CITY OF ALBUQUERQUE

Re: San Mateo Manor
513 Ortiz Dr. SE Albuquerque, NM 87108
Traffic Circulation Layout
Engineer's Stamp 10-16-25 (L18-D088)

Based upon the information provided in your submittal received 10-10-25, the above referenced plan cannot be approved for Building Permit until the following comments are addressed:

PROJECT NAME: **SAN MATEO MANOR**
 SHEET TITLE: **SITE PLAN**

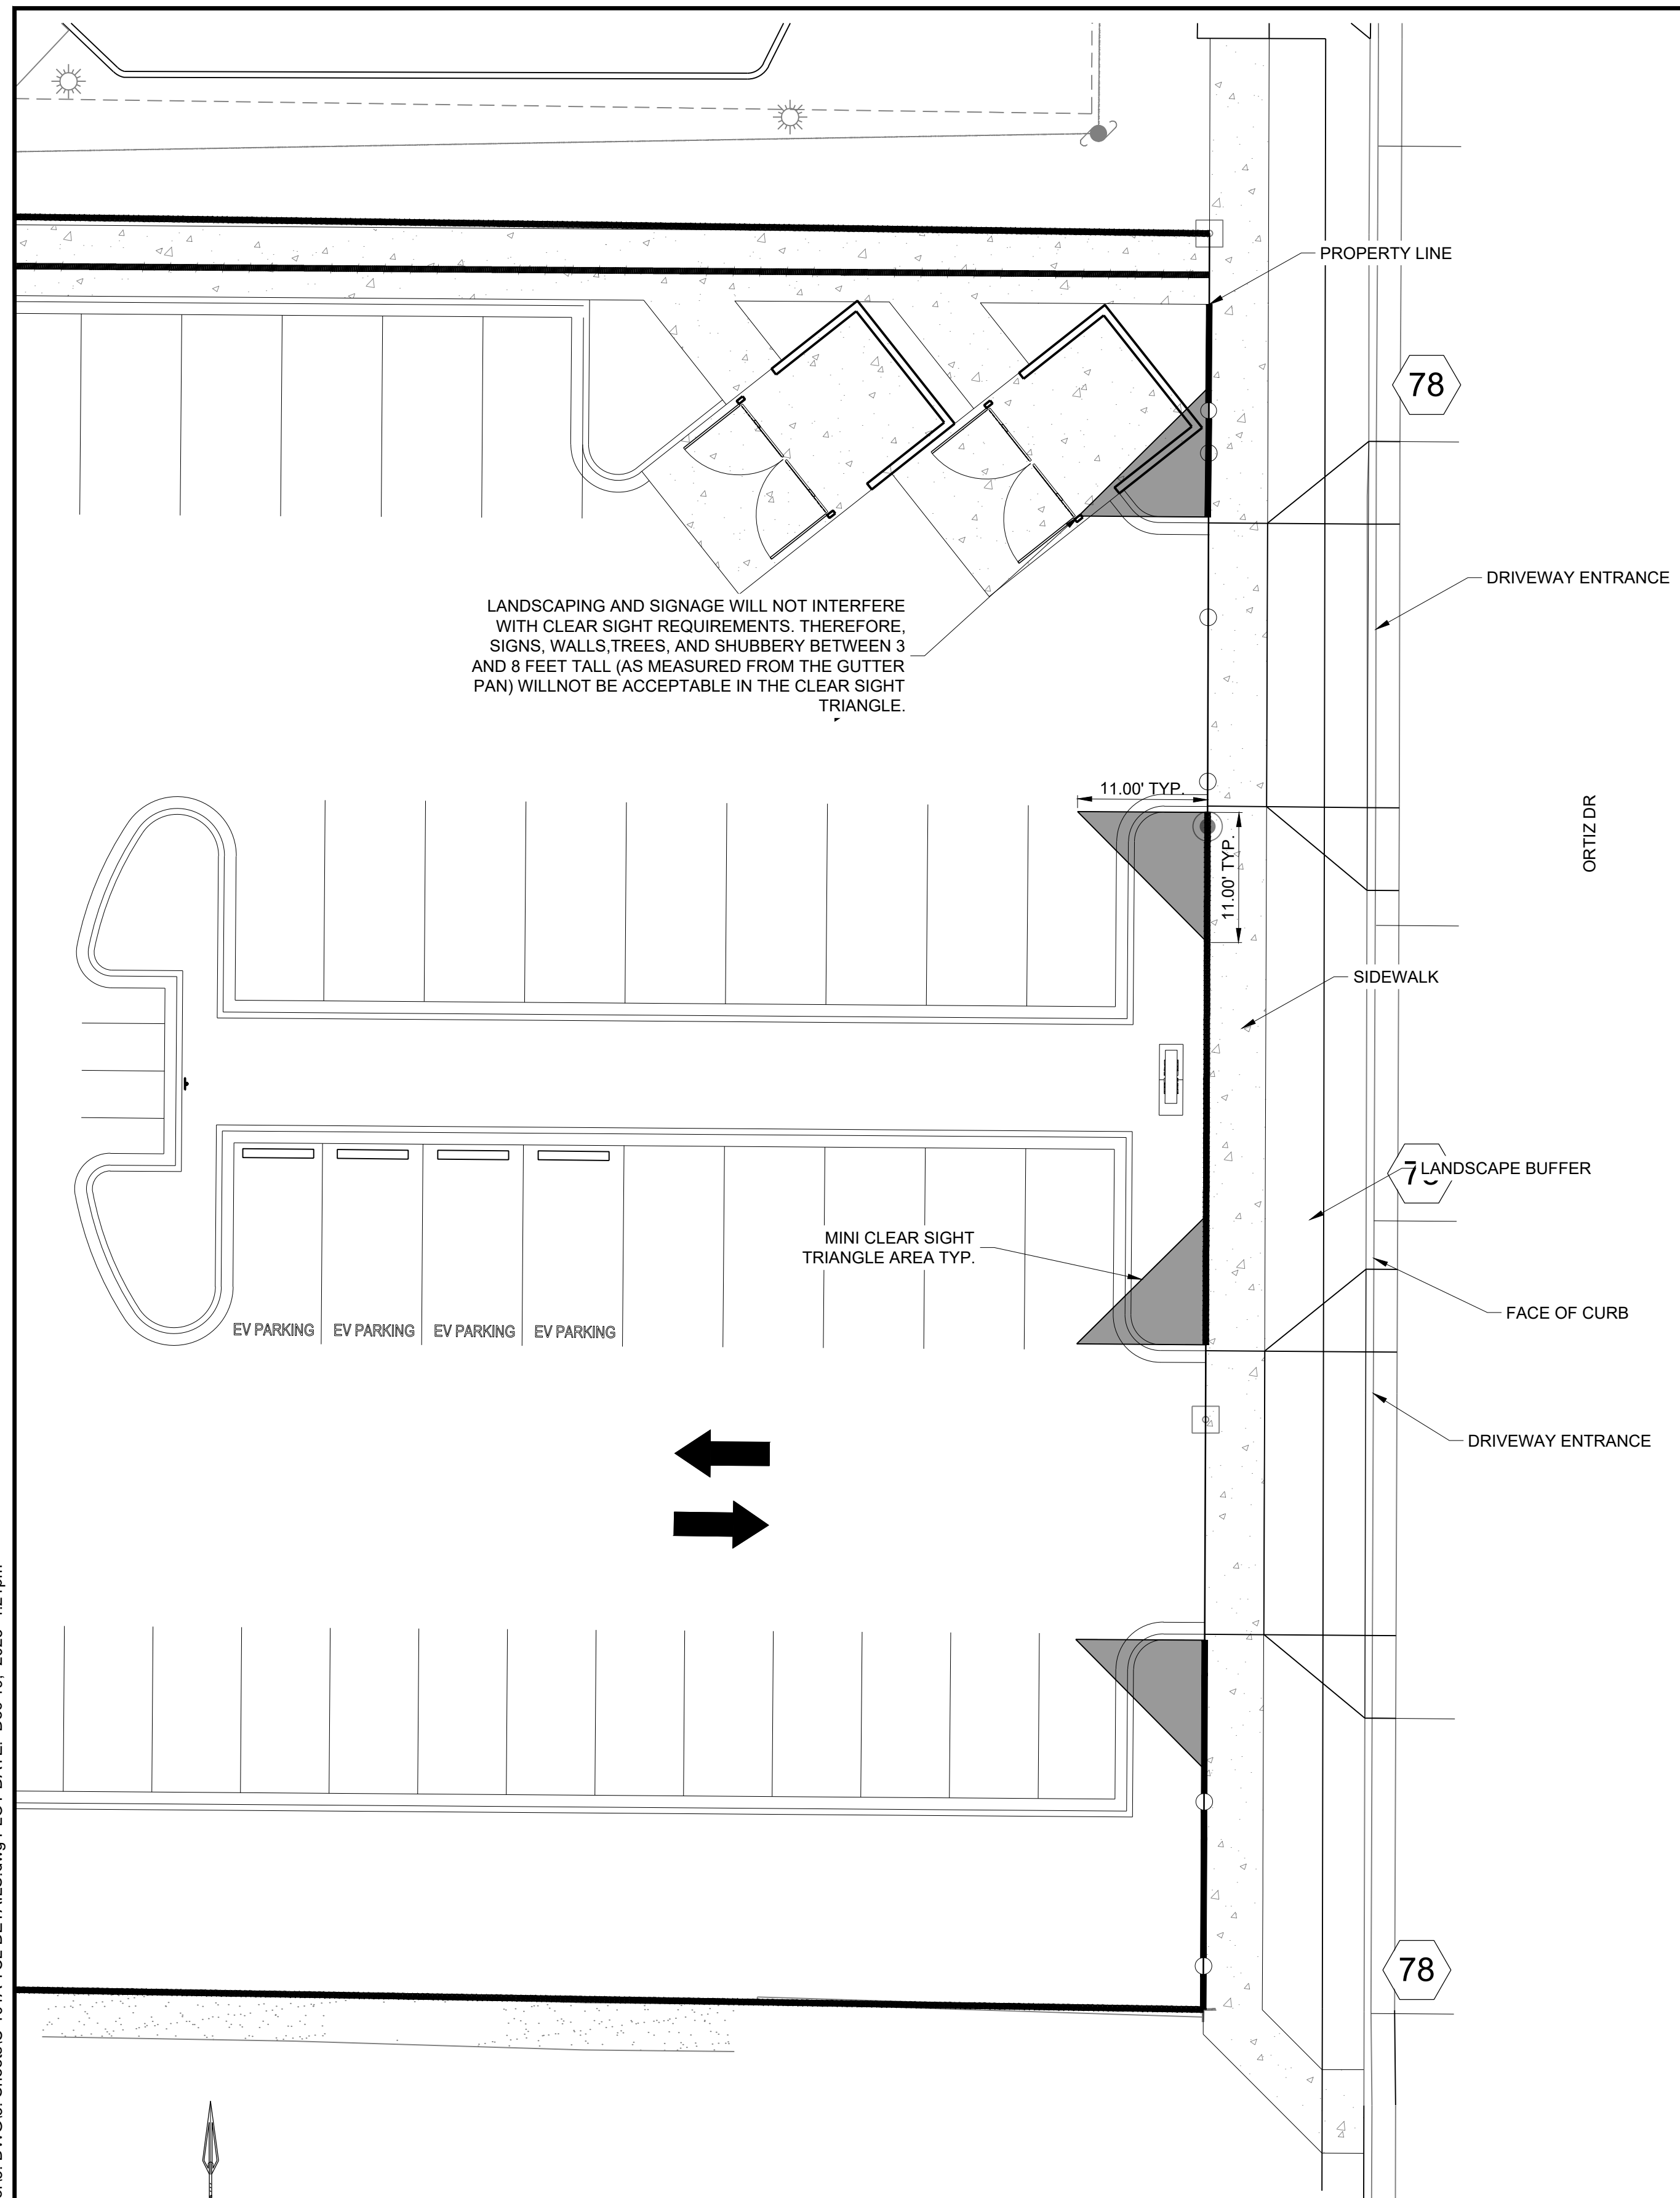
3. Clarify the extents of the current phase. Provide a phasing plan.
4. Identify the right of way width, medians, curb cuts, and street widths on San Mateo Blvd. SE and Ortiz Dr. SE.

5. Identify all existing access easements and rights of way width dimensions.
6. It appears the intentions are to close both driveway access on San Mateo Blvd. Unused curb cuts must be replaced with sidewalk and curb & gutter. Provide design details and applicable City standard drawings.

7. Show existing driveways on the adjacent properties and properties across the street from the site on Ortiz Dr. SE. Provide distancing from these existing driveways to nearby proposed site accessways.

8. Please provide a sight distance exhibit.
9. Show the clear sight triangle and add the following note to the plan: "Landscaping and signage will not interfere with clear sight requirements. Therefore, signs, walls, trees, and shrubbery between 3 and 8 feet tall (as measured from the gutter pan) will not be acceptable in the clear sight triangle.

10. Call out distance/width between proposed driveways.
11. Provide southern proposed drive aisle width.
12. All accessways to the site from the adjacent roadway shall be ADA-compliant.

14. All sidewalks along streets should be placed at the property line. Provide sidewalk design details and dimensions.
15. Parking spaces cannot be bisected by lot lines.
16. Provide Zoning approval documentation for reduction parking credits and EV accommodations. Verify parking calculations per IDO requirements.
17. Provide all parking signs design details.
18. Provide additional parking striping details. ADA access aisles shall have blue diagonal striping and the words **"NO PARKING"** in capital letters, each of which shall be at least one foot high and at least two inches wide, placed at the rear of the parking space so as to be close to where an adjacent vehicle's rear tire would be placed. (66-1-4.1.B NMSA 1978)

19. We notice the 4.5 foot ADA parking access aisle. Van access aisles must be a minimum 8 feet wide and all others must be a minimum 5 feet wide. Provide dimensions for each ADA stall and access aisles.

20. Per the DPM, a 6 ft. wide ADA accessible pedestrian pathway is **required from the public sidewalk to the building entrances**. Clearly show this pathway and provide details. Also, call out building entrance.

21. Per DPM, a 6 ft. wide ADA accessible pedestrian pathway is **required from the ADA parking stall access aisles to the building entrances**. Please clearly show this pathway and provide details.

22. Call out on-street parking spaces and provide design details meeting City standards. On-street parking spaces shall be designed according to the following guidelines:

28. Provide motorcycle parking space dimensions.

29. Provide motorcycle pavement marking "MC" for each motorcycle parking space.

30. Refuse vehicle maneuvering shall be contained on-site. The refuse vehicle shall not back into the public right of way.

34. Provide additional site circulation details. Are site access ways to function for two way flow or one way?

35. Driveway access must meet current City and ADA standards. Where the aisles will function for deliveries by larger trucks, refuse, and/or fire vehicles, etc., a 25 foot radius or larger is to be used. Provide City standard drawings that reflect design intentions.
